Re: Development R/64/17/PL PLANS.

Ref – Planning Application R/64/17/PL for Demolition of 1 No. dwelling & erection of 4 no. dwellings, at St. Mary's Close, Hurst Road, Rustington.

<u>SCALE</u>	<u>DATE</u>	<u>BY</u>
1:200	21-12-2016	PD
<u>NUMBER</u>	<u>SHEET</u>	<u>REV'N</u>
P1017	1	-

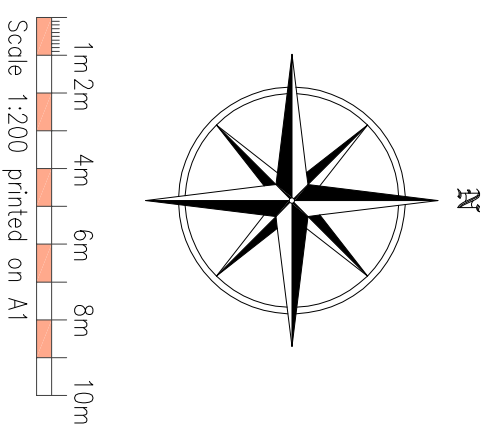
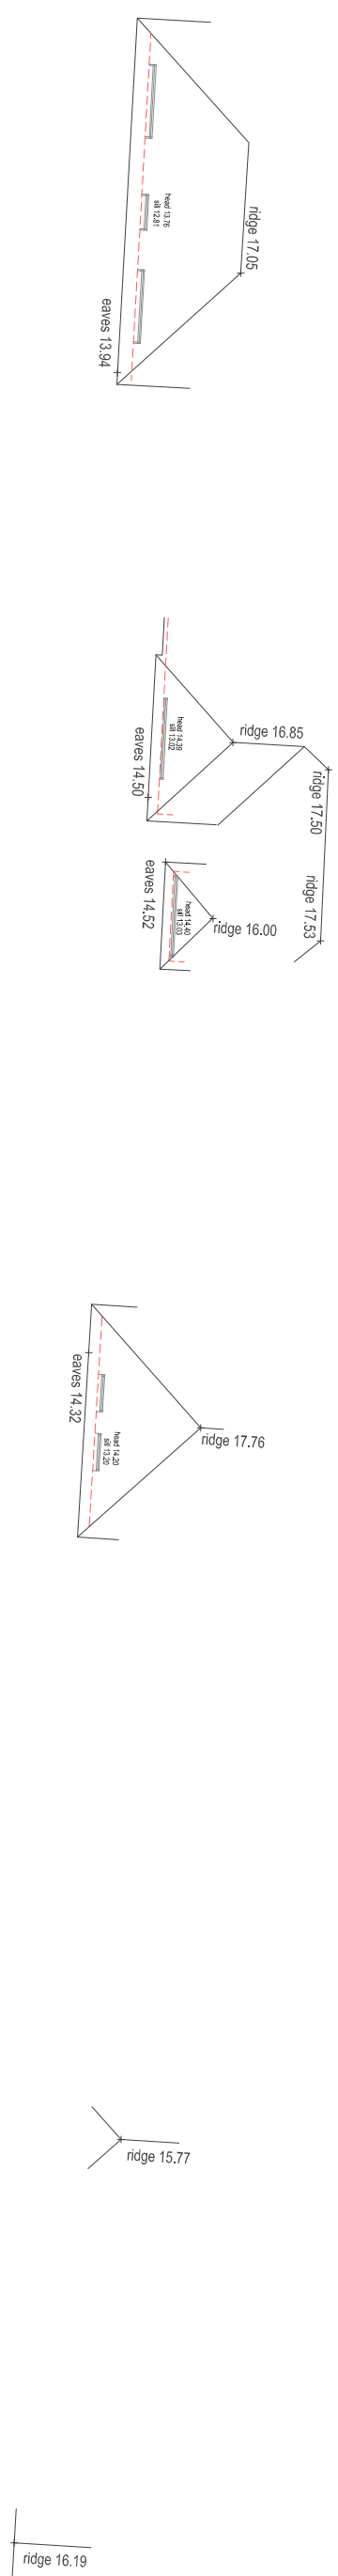
- In several places, the letter refers to the *'retention of the existing building line'* but clearly this isn't correct as demonstrated previously;
- The Landscaping and Trees sections talks about preserving trees and states that *'all existing trees in the rear garden will be retained'*. The Site Survey Plan drawing ref P1017 shows several trees and hedges that will clearly have to be removed during the construction phase;

Drg No: 151117_SS-01 Rev: D

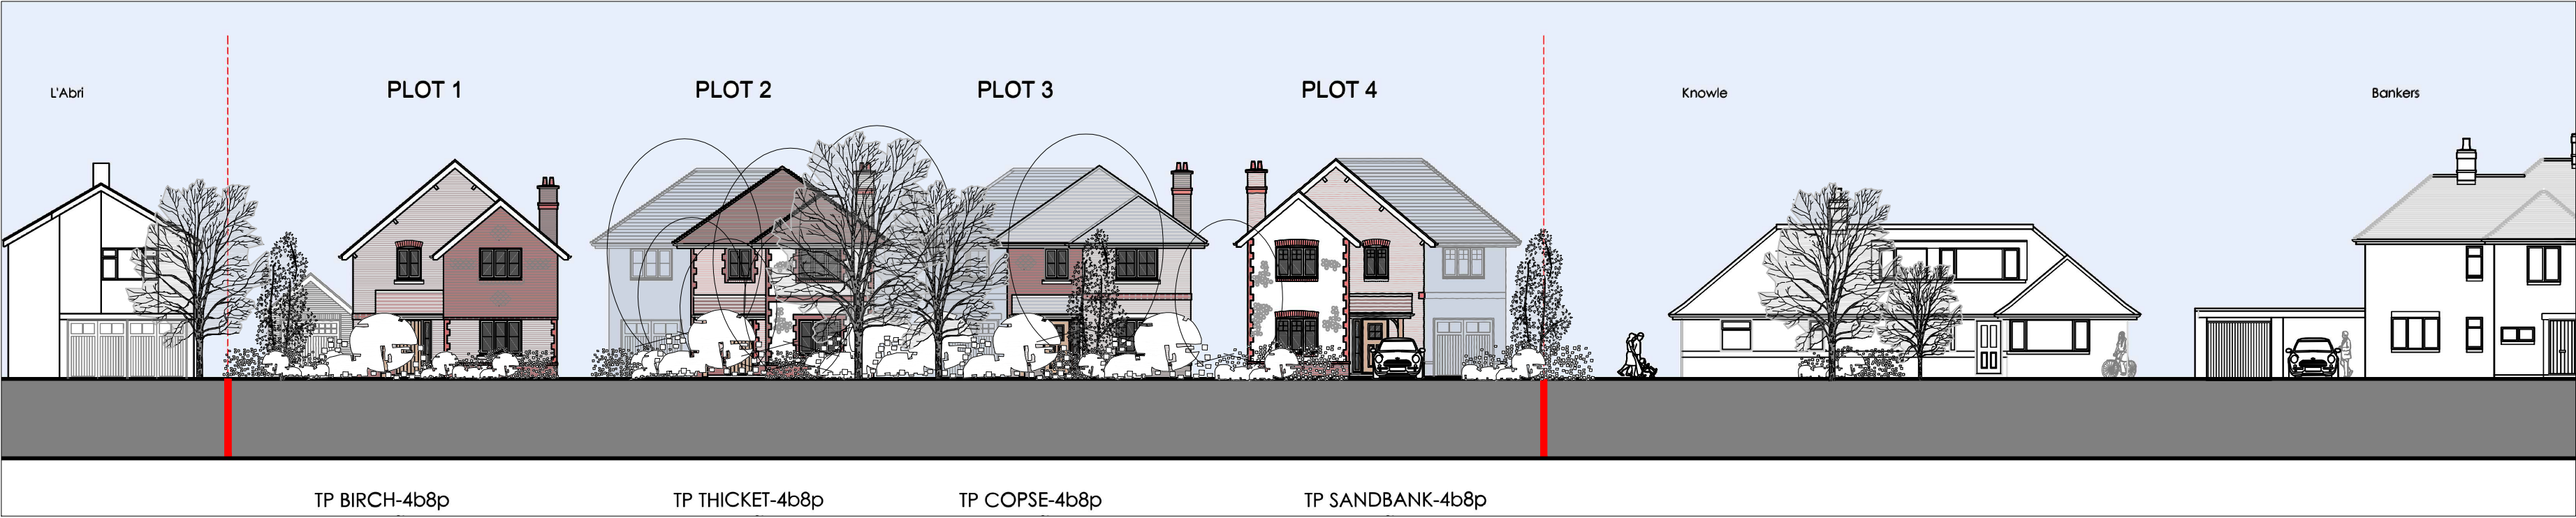
- There is a significant lack of dimensions leaving the development wide open to change if implemented;
- The architect has cleverly shaded out the rear portions of plots 2 and 3 to create an optical illusion of space between the properties;
- There appear to be several inconsistencies between the plans and elevations which again create the illusion of space. The following two extracts demonstrate how the spacing between plots 2 and 3 vary between the drawings, with the plan showing approx 2m and the elevation showing as little as 600mm between the eaves (measurements scaled as none provided on drawings);
